**EL PASO COUNTY PLANNING AND
 COMMUNITY DEVELOPMENT
 DEPARTMENT**

STORMWATER MANAGEMENT PLAN CHECKLIST

~~PPR 2034~~ **PPR219**

GRADING & EROSION CONTROL PLAN
CLAREMONT BUSINESS PARK 2 FIL. NO. 1 - LOT 2
JOB NO. 44-037
DATE PREPARED: OCTOBER 09, 2020
DATE REVISED:

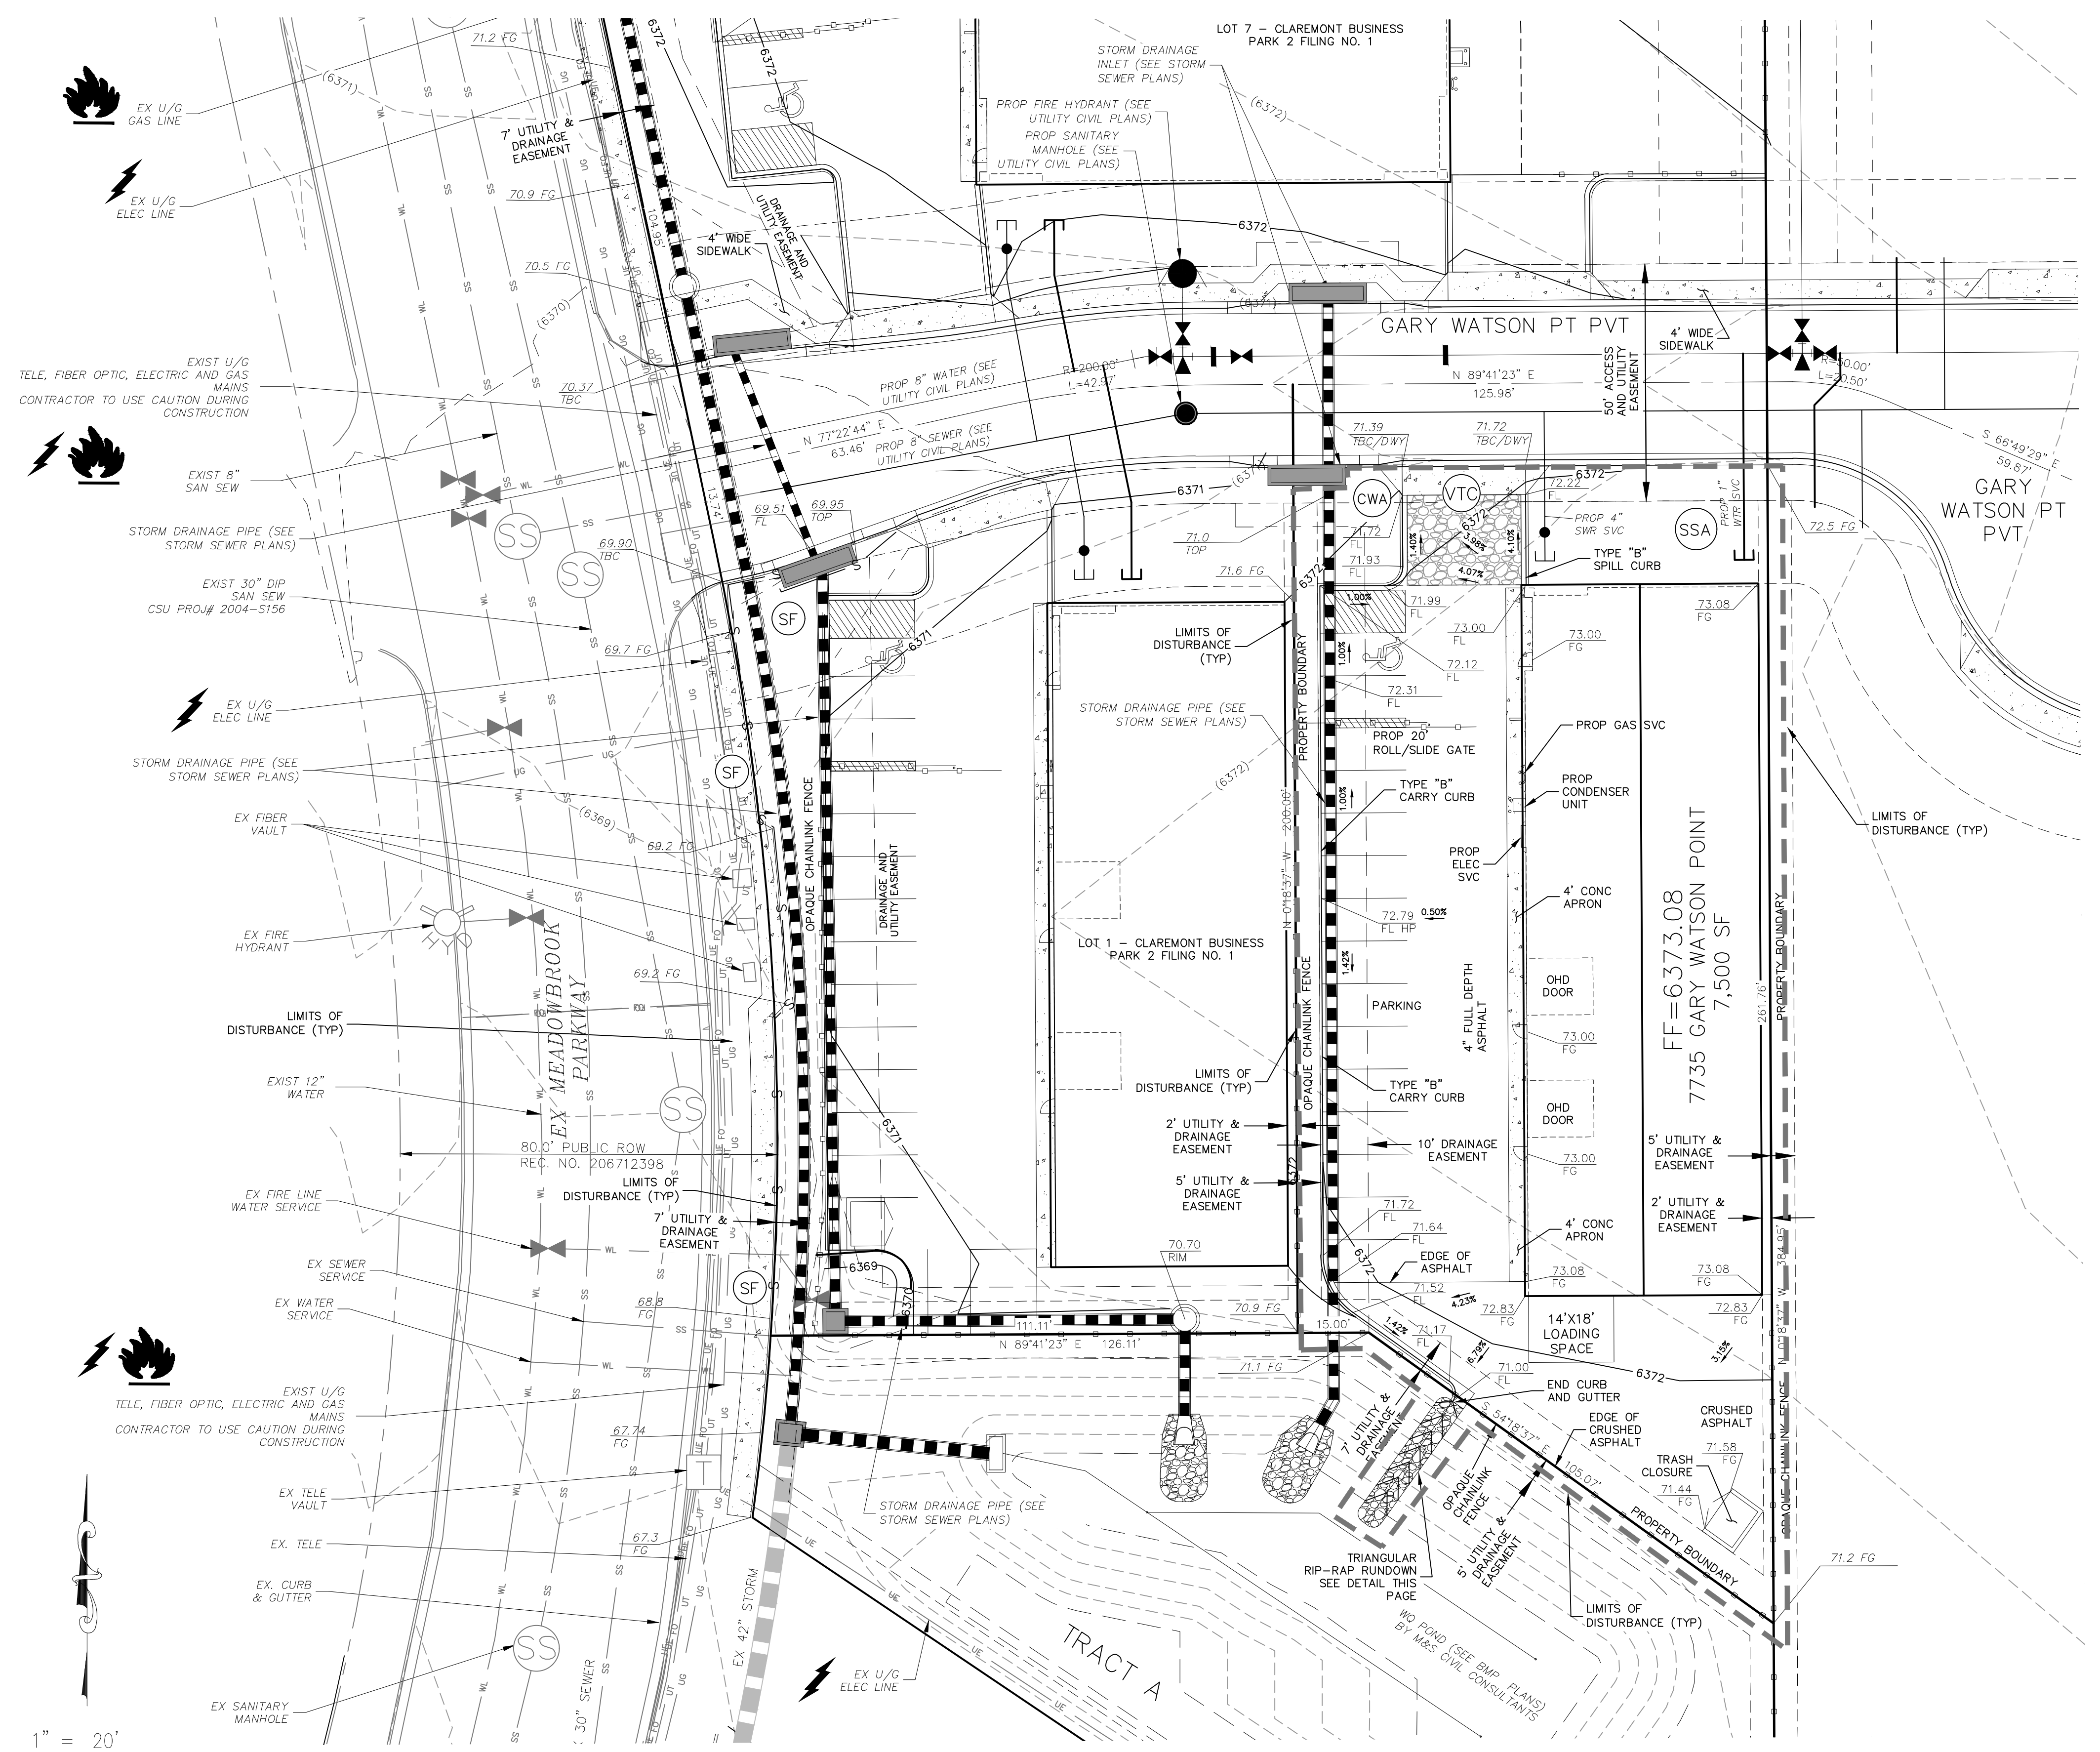
Applicant	PCD
b	Item 17f- No Asphalt Concrete Batch Plant are needd for the project		
<div style="border: 1px solid black; background-color: #f4a460; padding: 5px; display: inline-block;"> 17d - cut/fill was completed under EGP204 </div>			
c	Item 26 - This project has no reliances for control meadusres by other entites
